From: [REDACTED]
Sent: Friday, March 20, 2020 5:08 PM
To: [REDACTED]
Cc: [REDACTED]
Subject: Summerhouse, shed and fence at 1 Park Road, Gisburn

Summerhouse, shed and fence at 1 Park Road, Gisburn

PLAN & ELEVATIONS OF GARDEN ROOM/OFFICE & STORE FOR.
 MR & MRS P HARGREAVES 1 PARK RD GIBBURN.

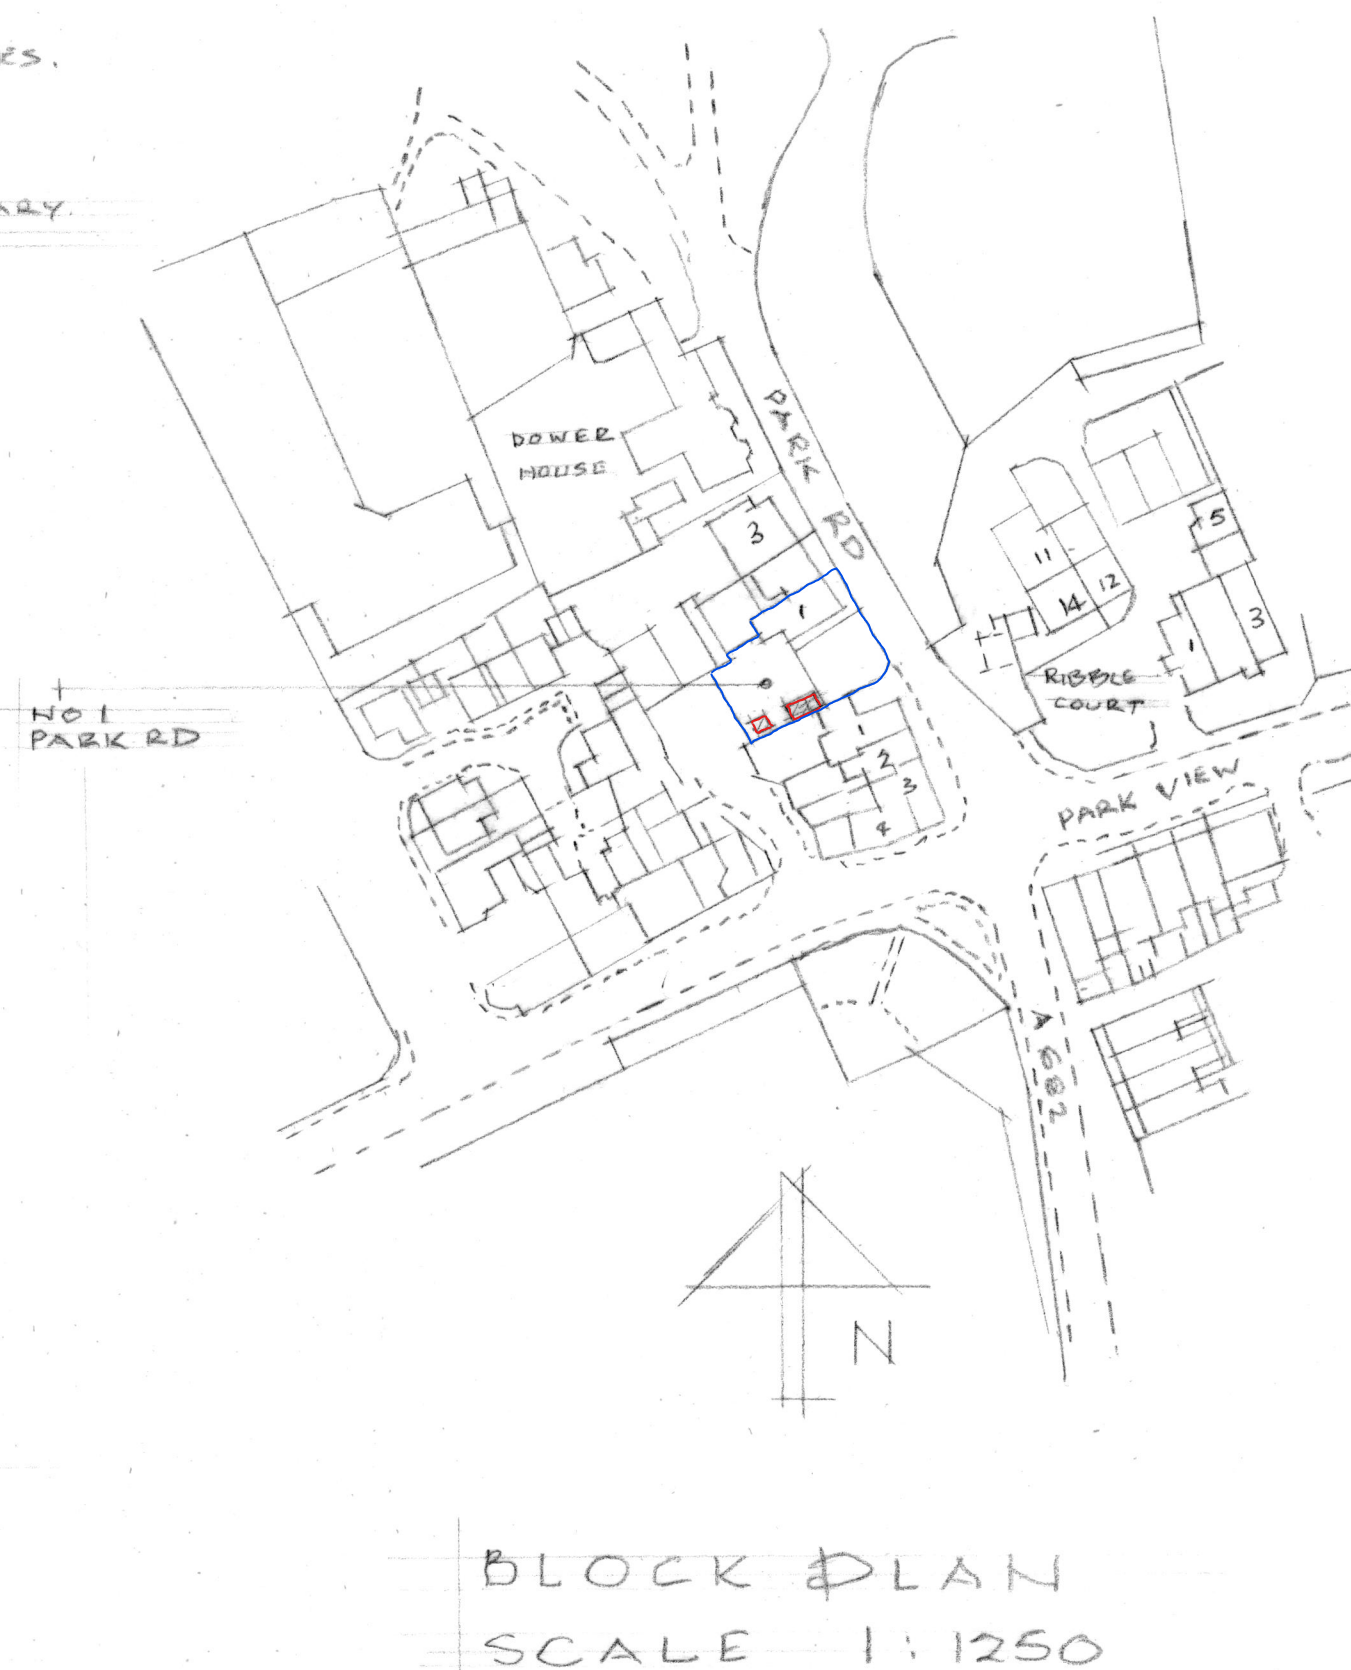
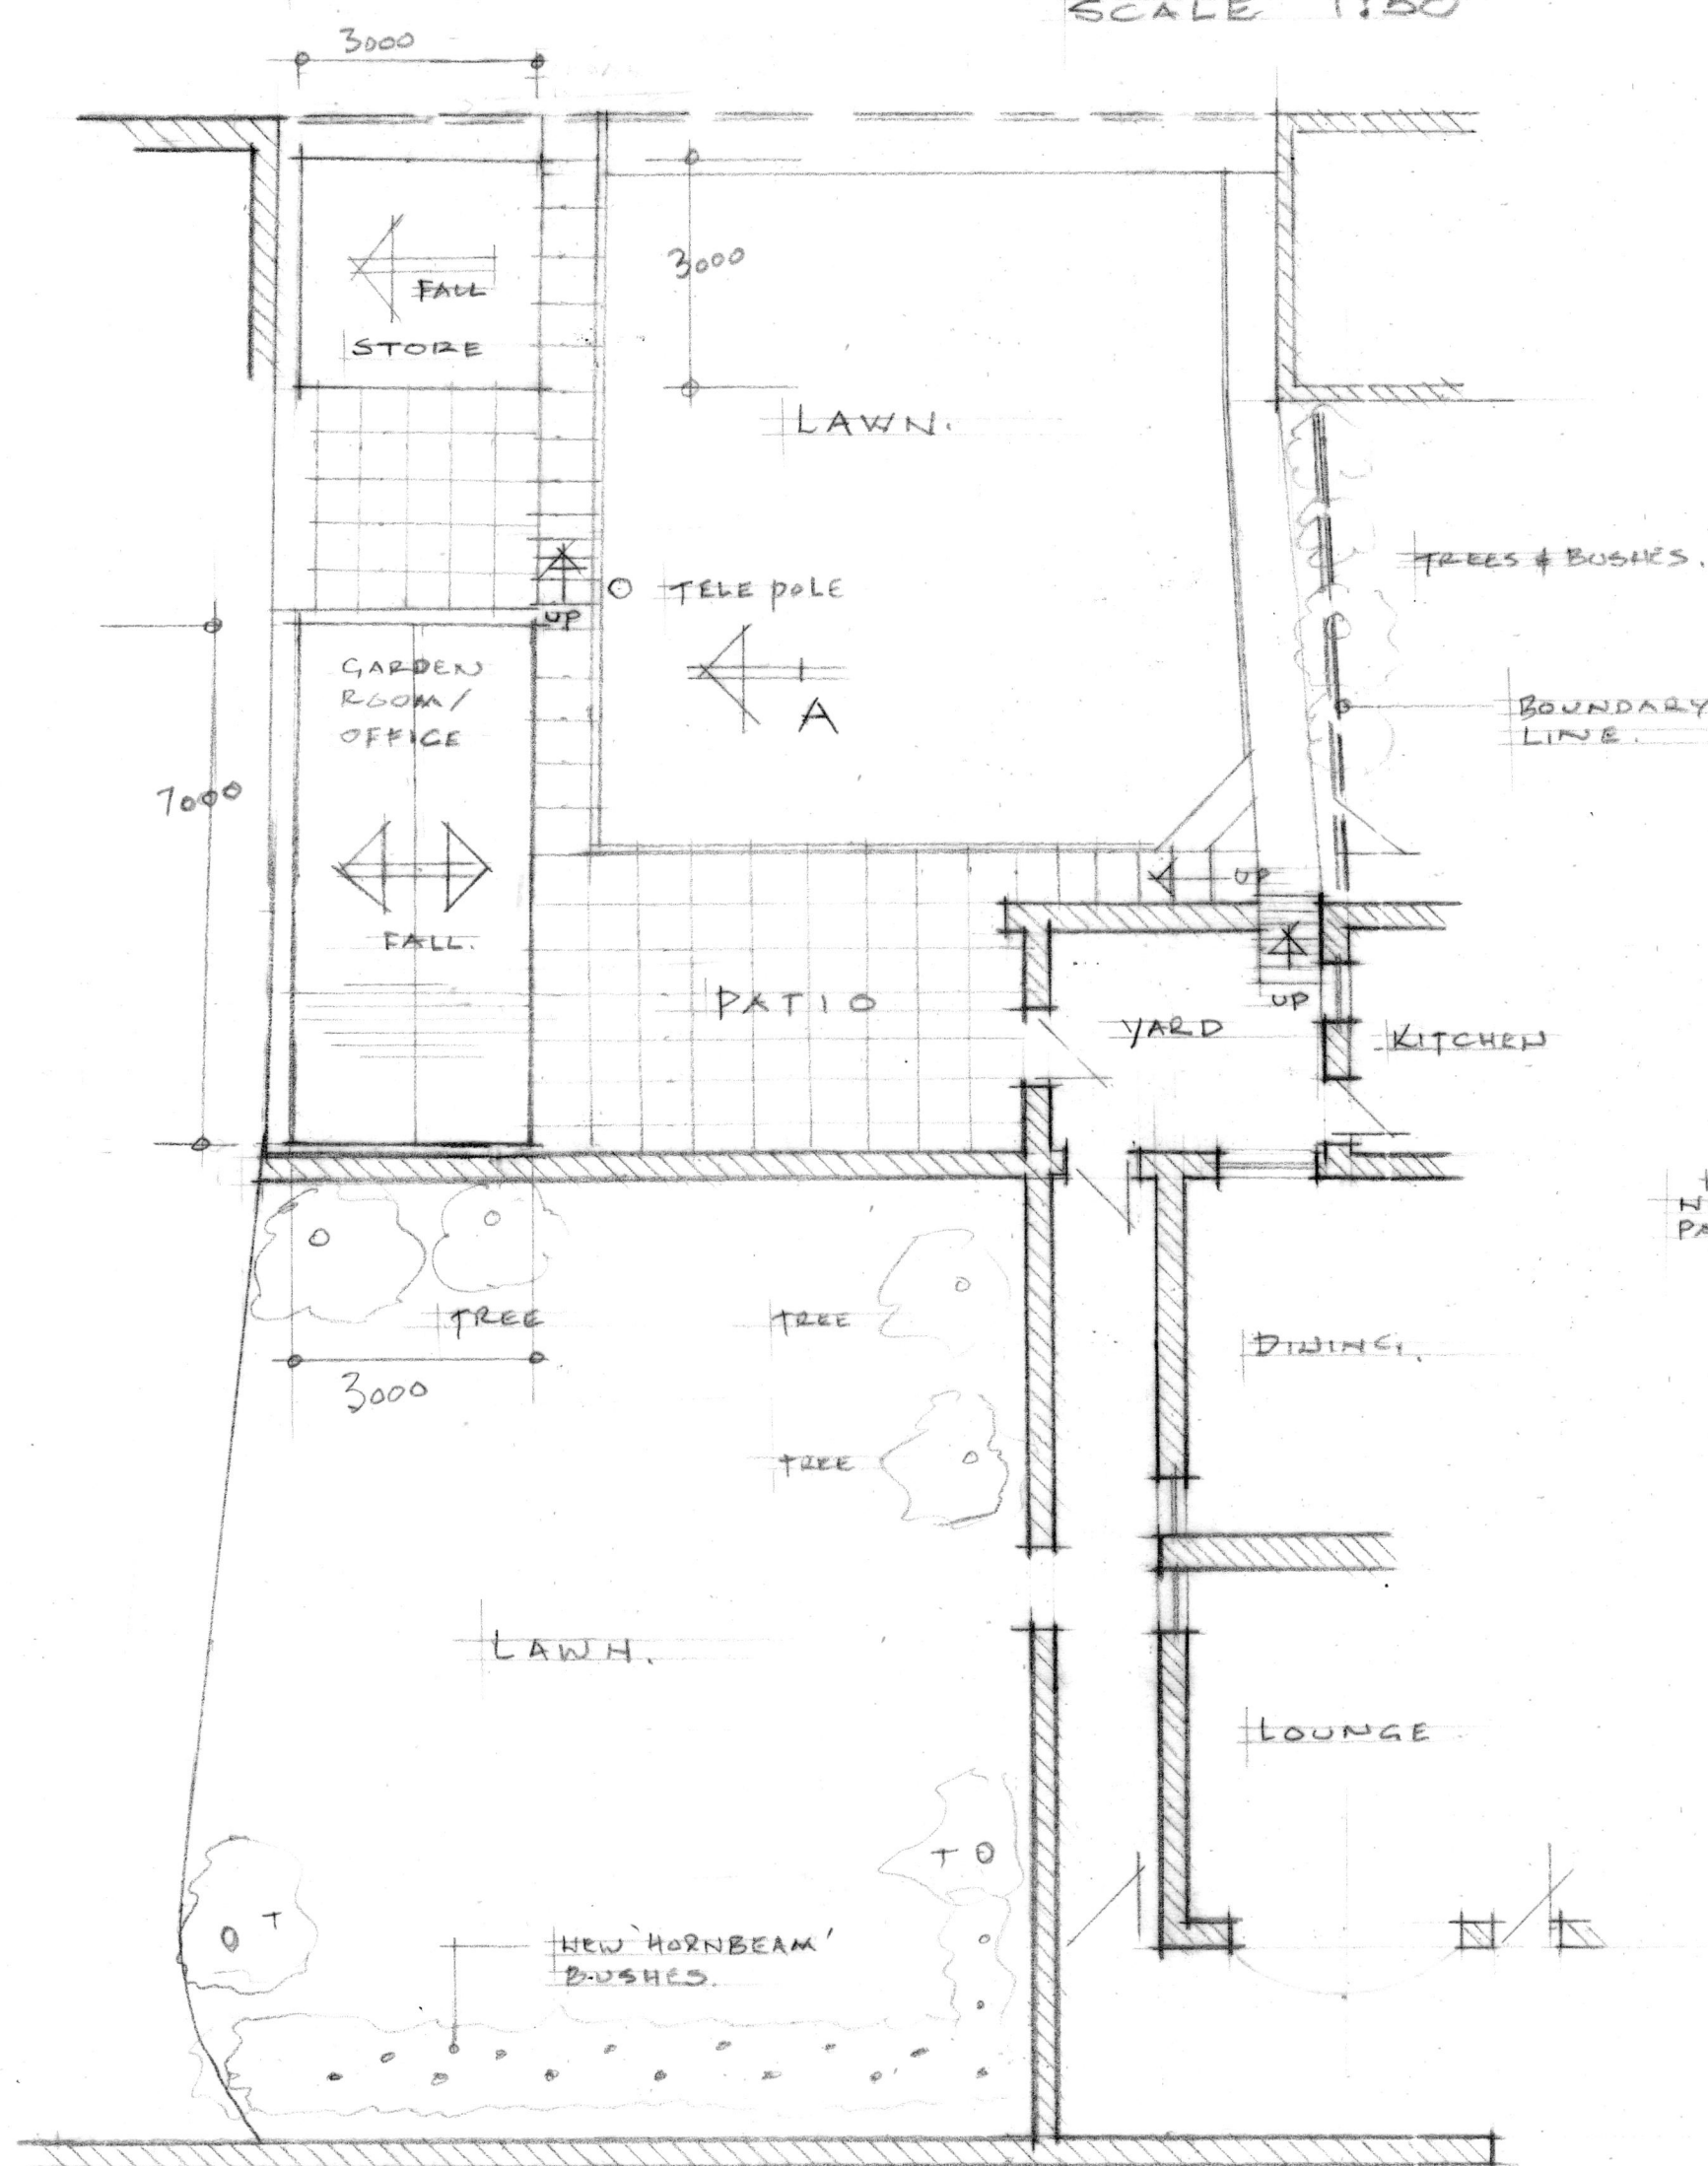
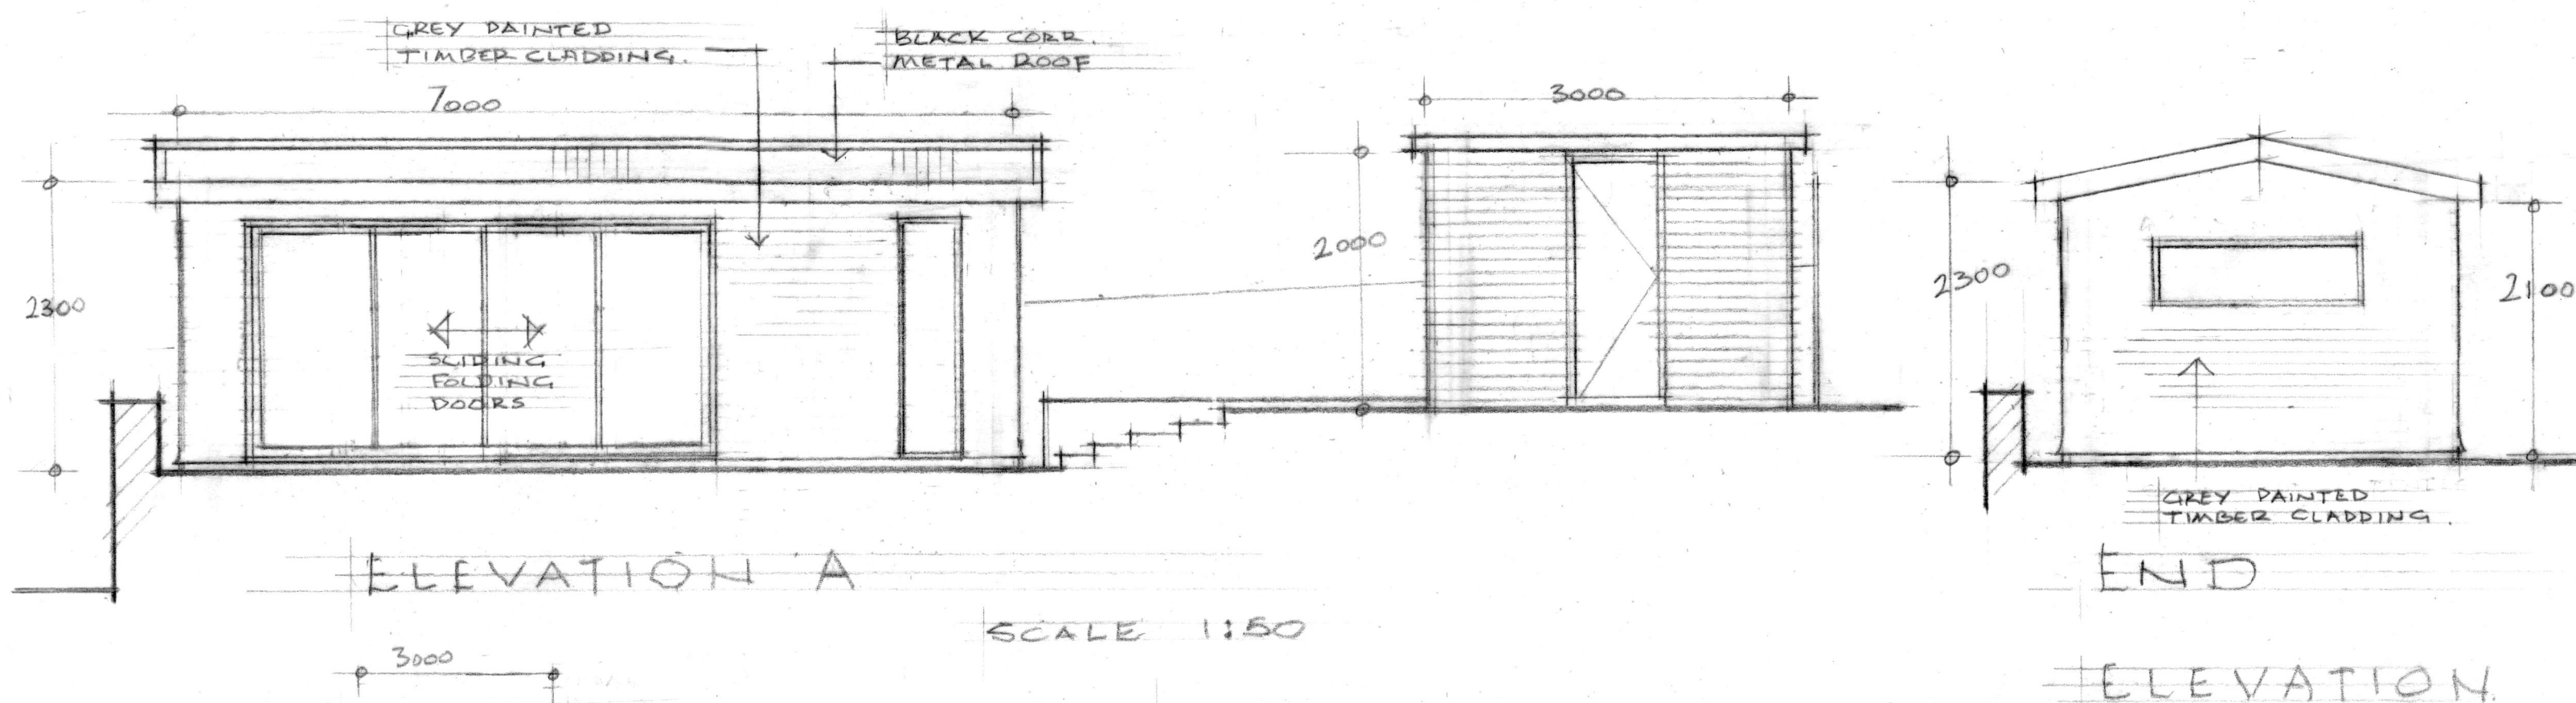
In my opinion, the summerhouse has the most significant adverse impact and is prominent, conspicuous and incongruous because of its elevation, materials (stone is the vernacular for buildings and boundary structures) and form (pitched roofs characterise the listed building and nearby historic buildings). This is harmful to the setting of listed buildings, the character and appearance of Gisburn Conservation Area and the setting of Gisburn Park Historic Park and Garden (Park Road is an important historic access to the Park).

I would confirm, that I cannot envisage alterations to the summerhouse or listed building setting which would remove all harm (see NPPF 193 and 194) <https://www.gov.uk/guidance/national-planning-policy-framework/16-conserving-and-enhancing-the-historic-environment> and will not be inviting the submission of a planning application (although it is your right to do so) to further consider this element of works.
